Application for Planning Permission for Works or Extension to a Dwelling

Development: Erection of conservatory to the rear
Location: 15 Old Point Middleton-On-Sea PO22 7RY

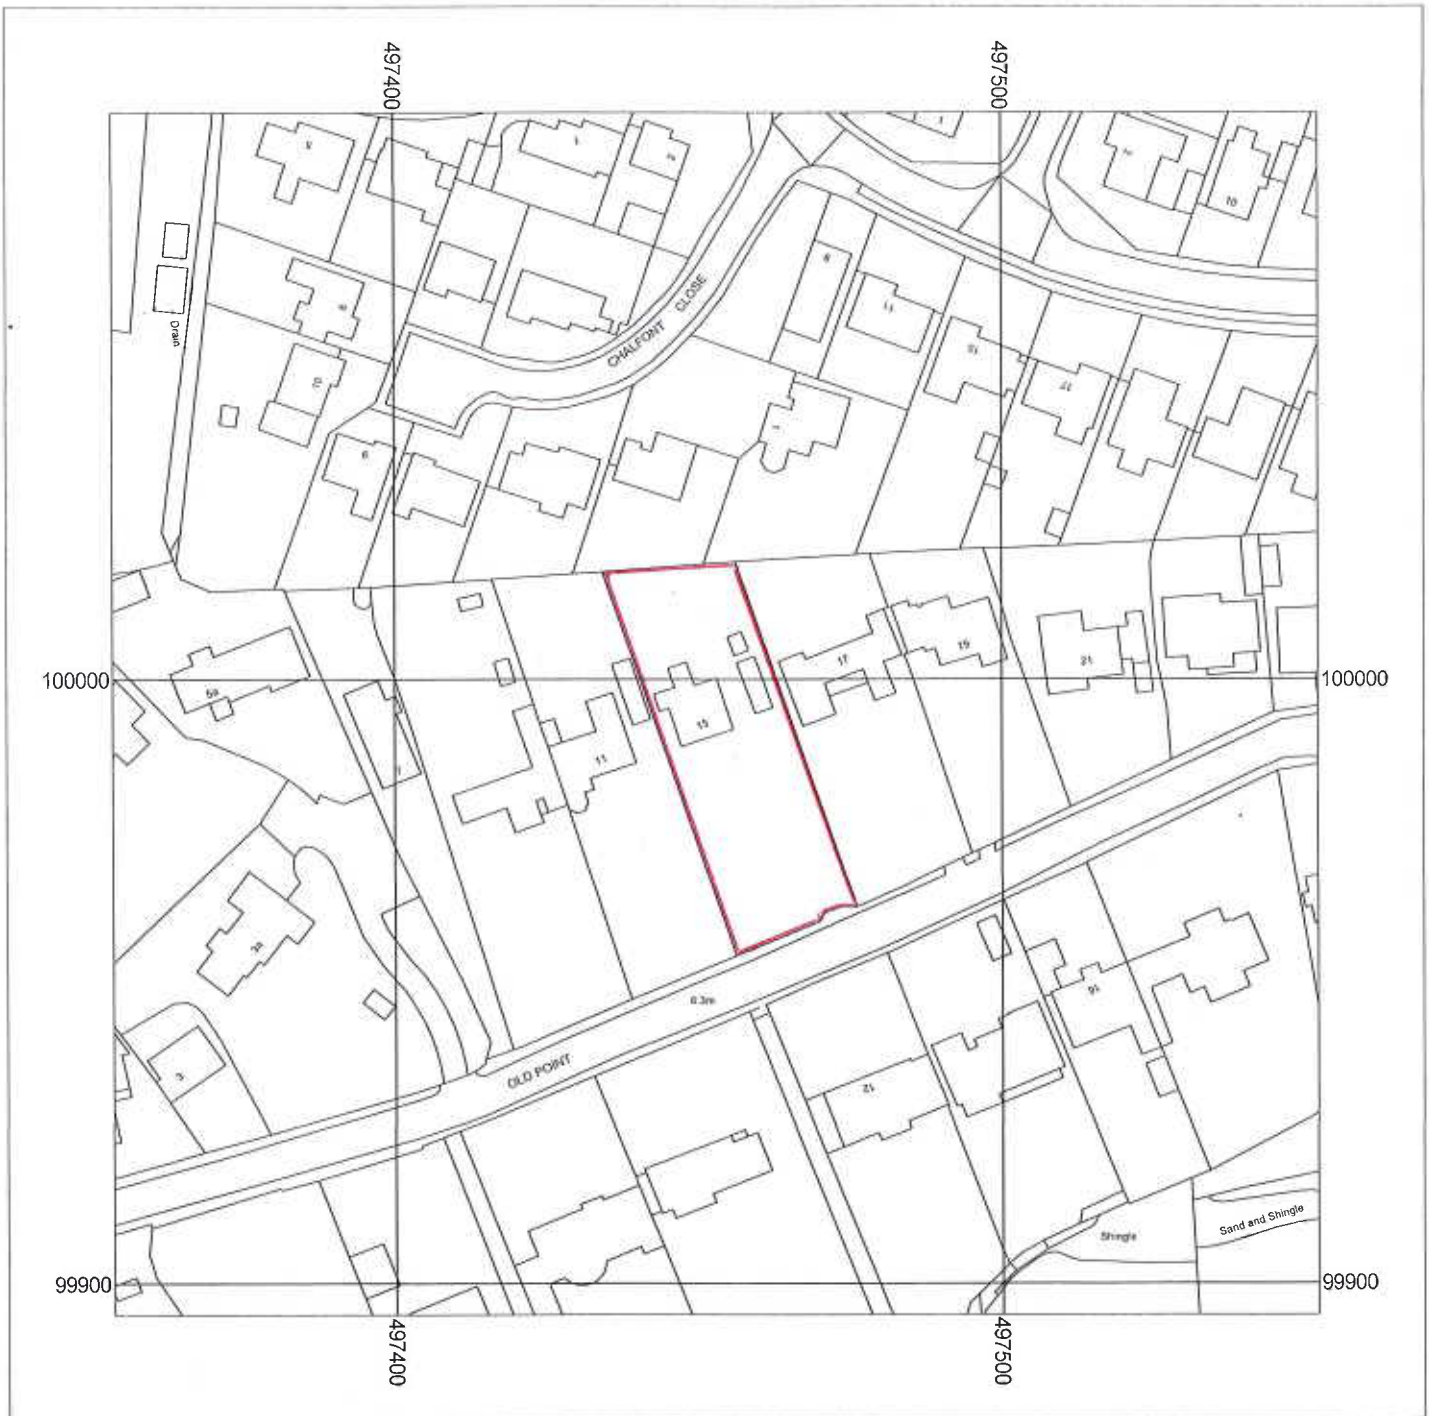
Block Plan

You are required to have dimensions from the proposed extension(s) to all site boundaries. Please amend.
